Submission from Dr Geoffrey Radley MCIEEM (Retired) OBE

Principal Issue 8: Land use and soils

Principal Issue 4: Ecology and Biodiversity

Appendix 2 – Green Infrastructure Strategy Plans

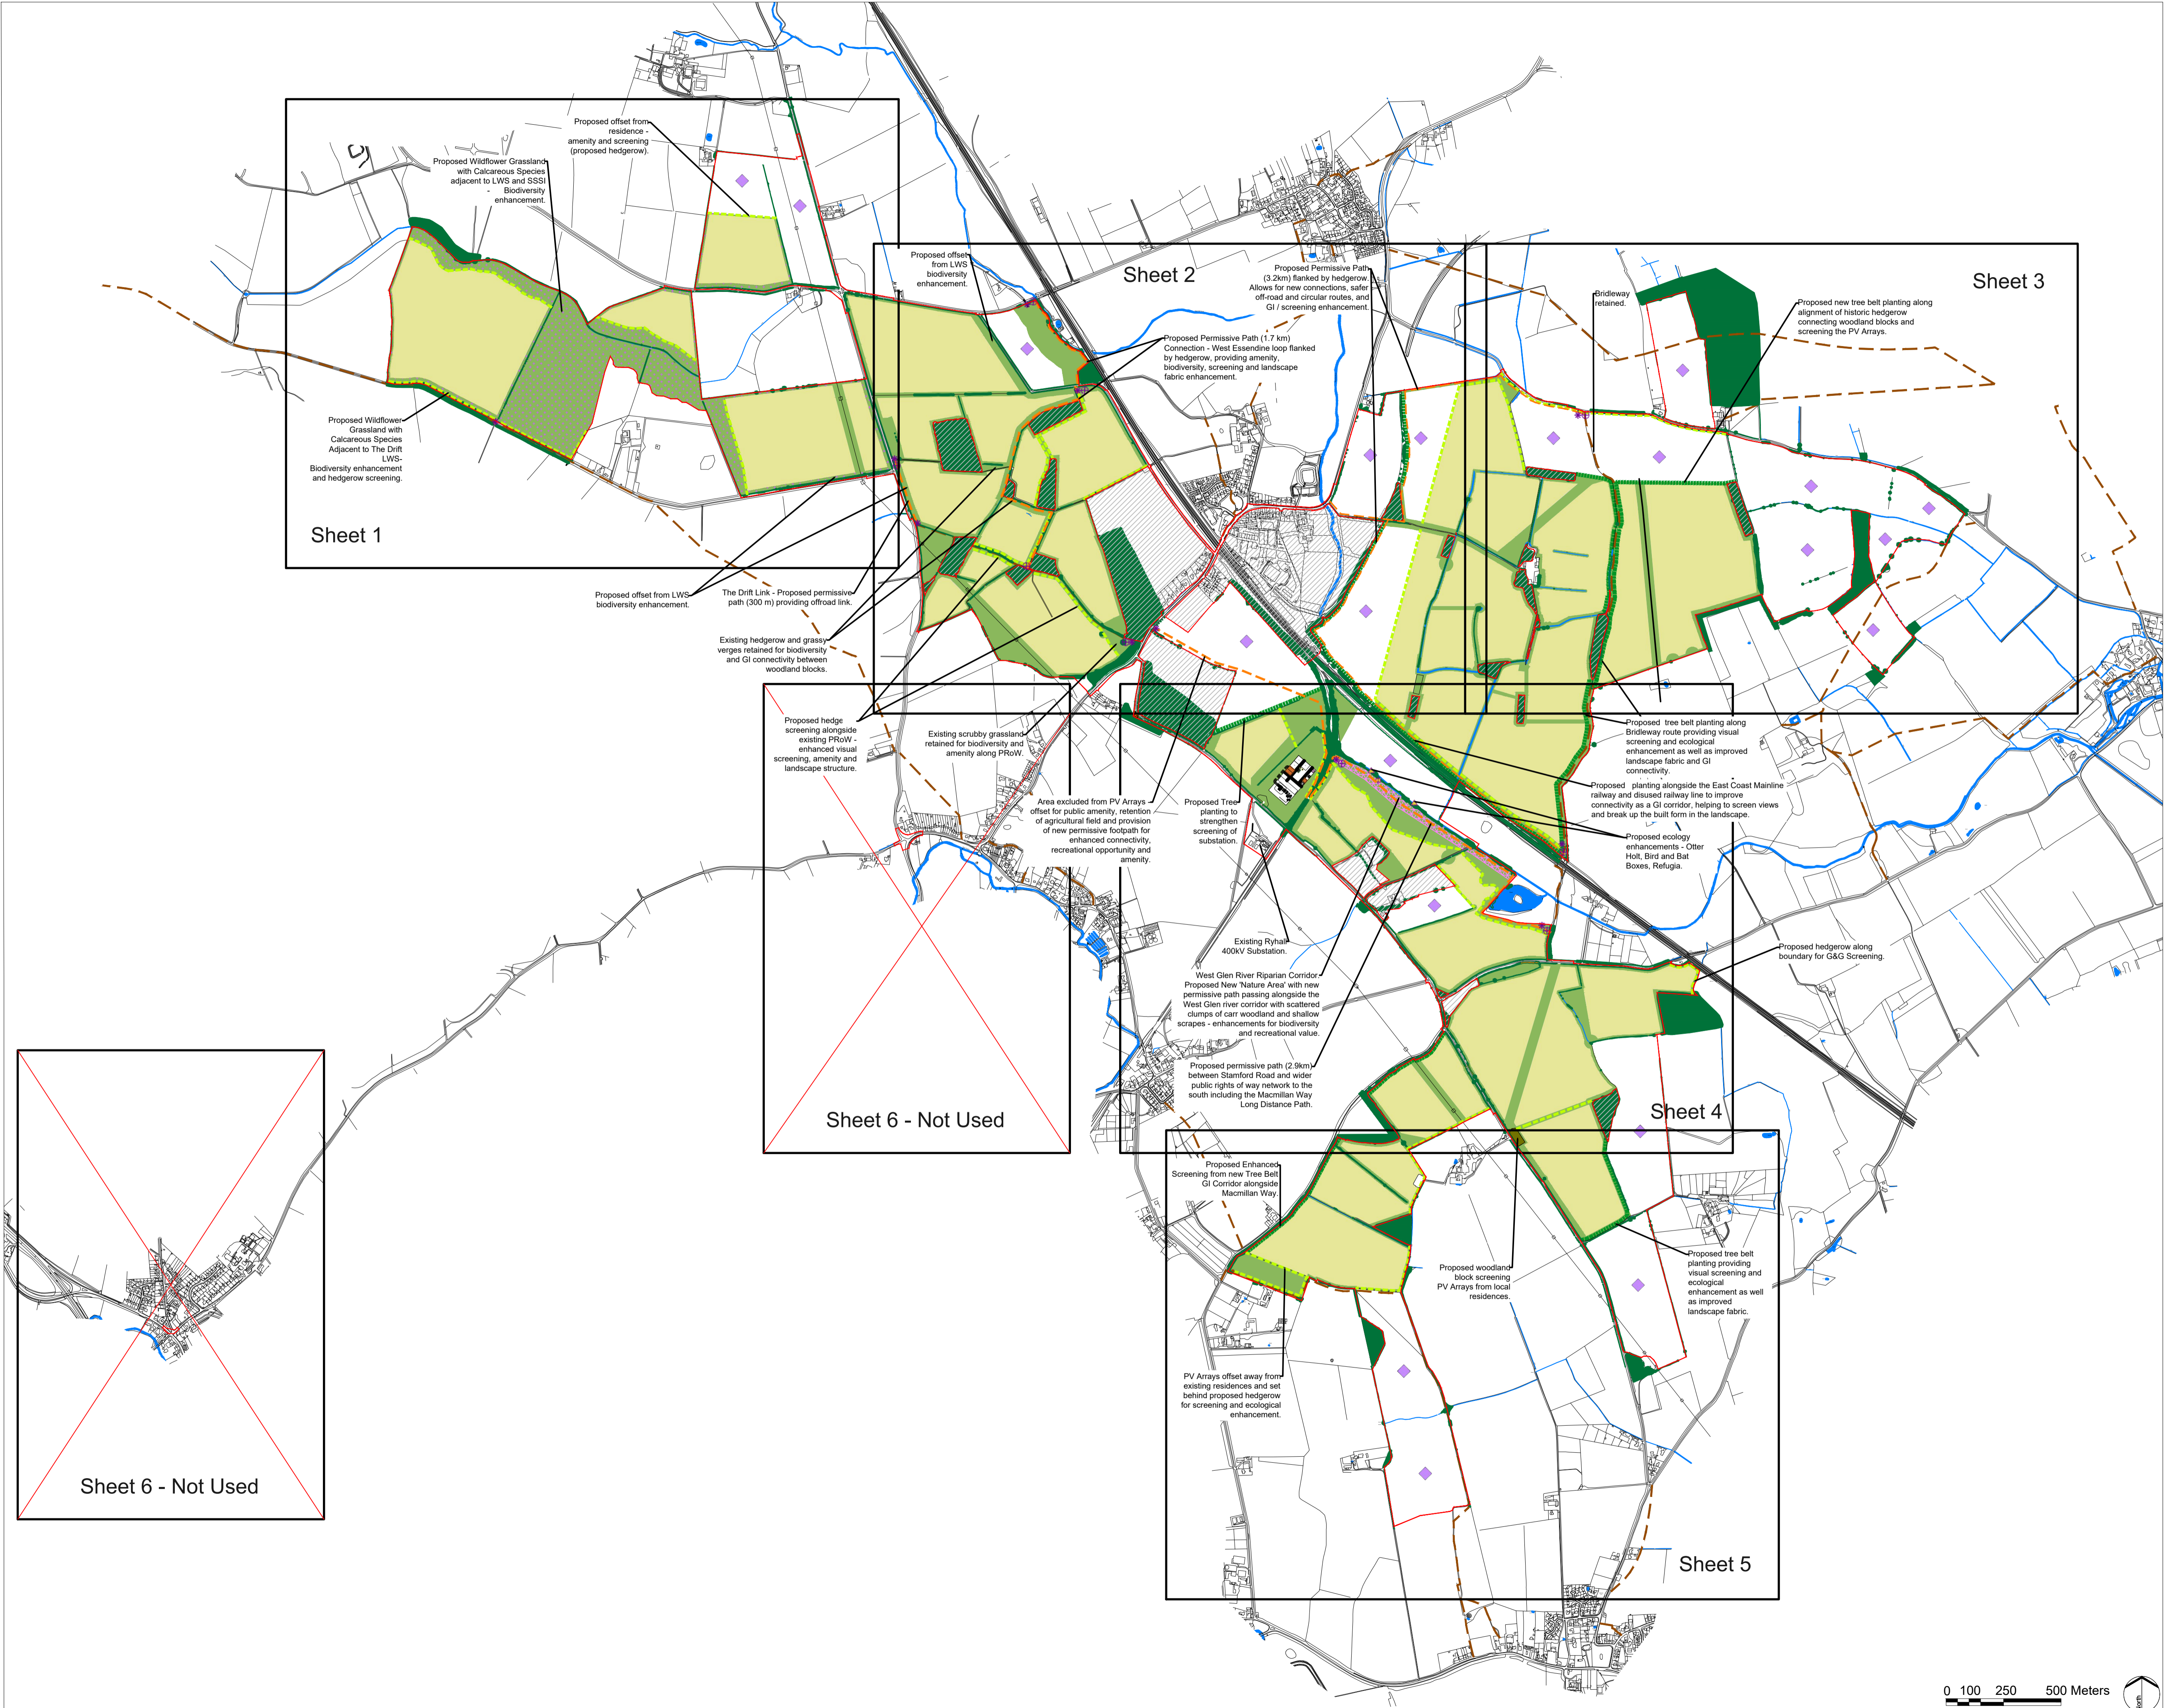
I am therefore concerned that the measures proposed to enhance the retained arable in the outline Landscape and Ecology Management Plan (oLEMP) do not include measures intended to benefit wintering birds.

The outline Landscape and Ecology Management Plan (oLEMP) states that the areas of wildflower grassland to be established using calcareous species will be cut every two years on rotation in late summer. There has been extensive research on the establishment of

species rich grasslands. This strongly suggests that, on the relatively fertile soils of former arable fields, this cutting regime will not be sufficient to prevent the grasslands becoming dominated by a small number of vigorous grasses, with the other sown plant species being eliminated as a result.

The oLEMP states that grassland under the solar arrays will either be managed by rotational sheep grazing in autumn and winter to allow for nesting birds or, if no grazing is possible, will be cut twice per year in April/May and September.

Cutting in April/May would be disastrous for any ground-nesting birds, as was found during the early days of agricultural set-aside, so this should be avoided at all costs.

The outline Landscape and Ecology Management Plan envisages establishing wet woodland and constructing shallow scrapes in this river corridor. Whilst this will have some biodiversity benefits, it is likely to have little impact on the hydrology of the West Glen River.

I would strongly argue that the developers should be obliged to include management for ground-feeding wintering birds in the Landscape and Ecology Management Plan as a condition of the consent, both to mitigate the direct impact of this development and to help ensure that there is no cumulative effect should a series of similar solar arrays be given consent on arable farmland in the East Midlands.

To avoid this, the areas should be cut more frequently (whilst still allowing species to flower and set seed) and/or they should be included in the areas to be grazed by sheep in late summer and winter, using a grazing regime similar to that used on the nearby Barnack Hills and Holes National Nature Reserve.

Grazing by sheep is a much better option for managing these areas and I would urge that this should be a condition of the consent. Grazing by sheep would retain some agricultural production from the area and would avoid the considerable labour costs of cutting large areas in and amongst the panels.
